From: Anita Gardner
Sent: 13 September 2017 16:08
To: Planning.Responses
Subject: FW: FG/108/17/DOC - Condition 4 Internal Noise levels - Ferring

Subject: FG/108/17/DOC - Condition 4 Internal Noise levels - 1 Bennett Gardens, Ferring

'Refuse application for discharge of Condition 4 in respect of post validation testing to determine compliance with the requirements of BS8233:2014. Those Acoustic Reports provided by Sound Advice Acoustics Ltd, Ref SA -5031 in respect of Plot 1-4 (1st to 4th July 2017) and SA - 4993 in respect of Plot 37 - 40 (24th to 27th June 2017) clearly demonstrate an unacceptably high incidence of peak noise, defined as 45dBLAFMax, within first floor bedrooms during night time hours. This is despite investigations having taken place predominantly over the week end, when traffic flow might be expected to be less. Please provide detail of those further mitigation measures which will be provided to achieve the required standard. Any further post completion validation testing to be carried out on at least 2 days within that period Monday to Friday.

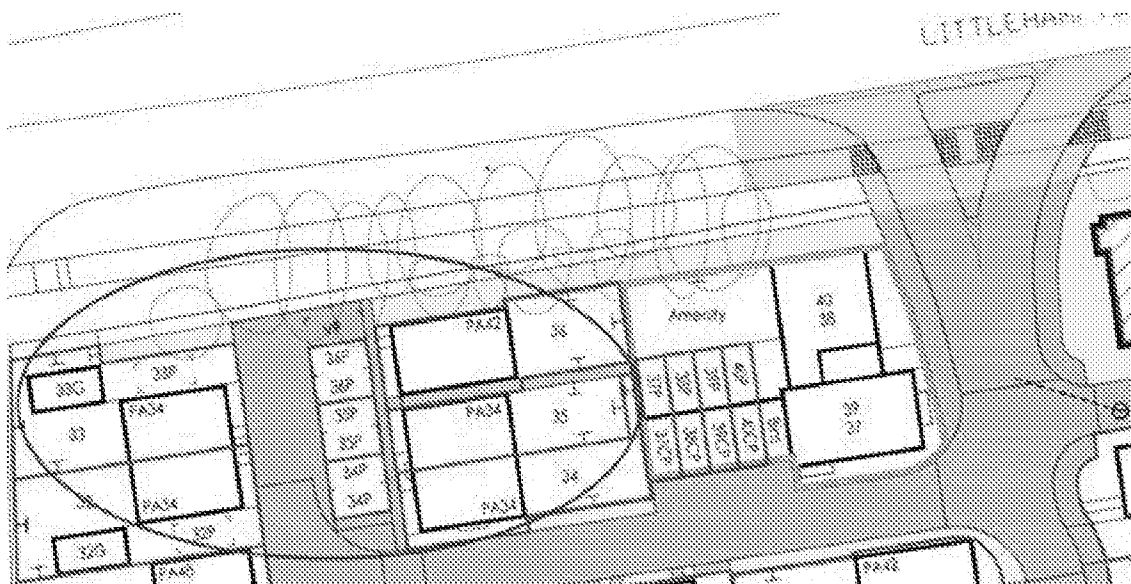
My question was regarding the remaining units which as you will see in the below image have only plot 36 adjacent to the a259 with 35 and 34 protected by 36.

We intend on carrying out the testing in 2 weeks time so to avoid any disruption I wanted to check if this was an error and instead the condition should state 33 and 36 or if you would like me to carry out testing to the 3 units listed in the condition?

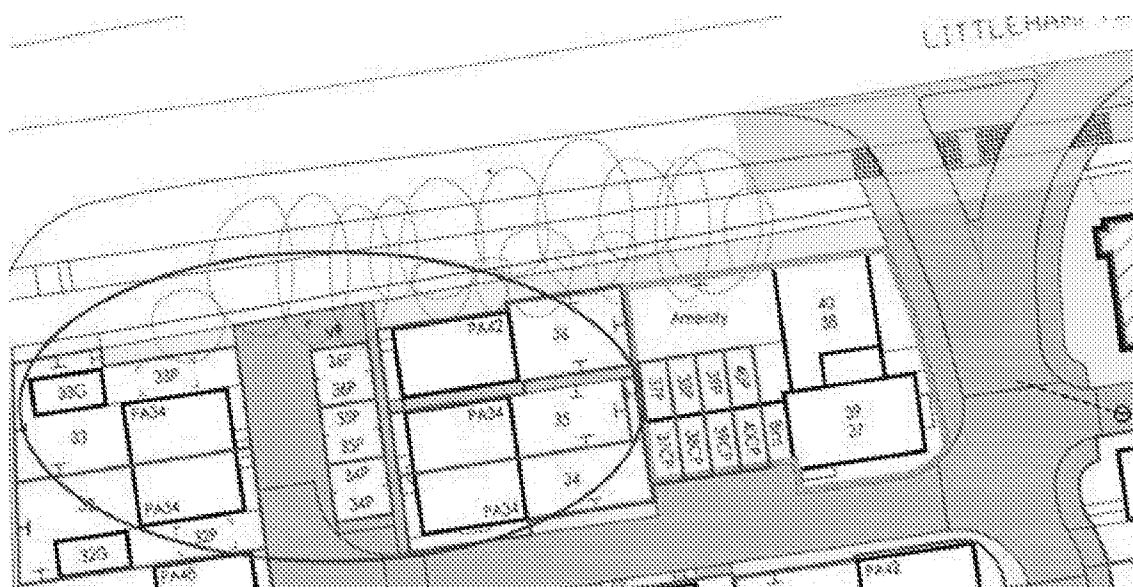
Going forward we still are due to test more plots alongside the A259. The condition does ask for testing of 3 plots (34-36) however only one of those plots front on to the A259 and we intend on testing the two left on site that do (33 and 36). Please see the exert of the site below for reference.

Can you please confirm that you would like Taylor Wimpey to test plots 33 and 36 instead of what is stated in the condition as 34-36 that contains two units that are shielded by plot 36 or if you would like us to test all 3 units as stated?
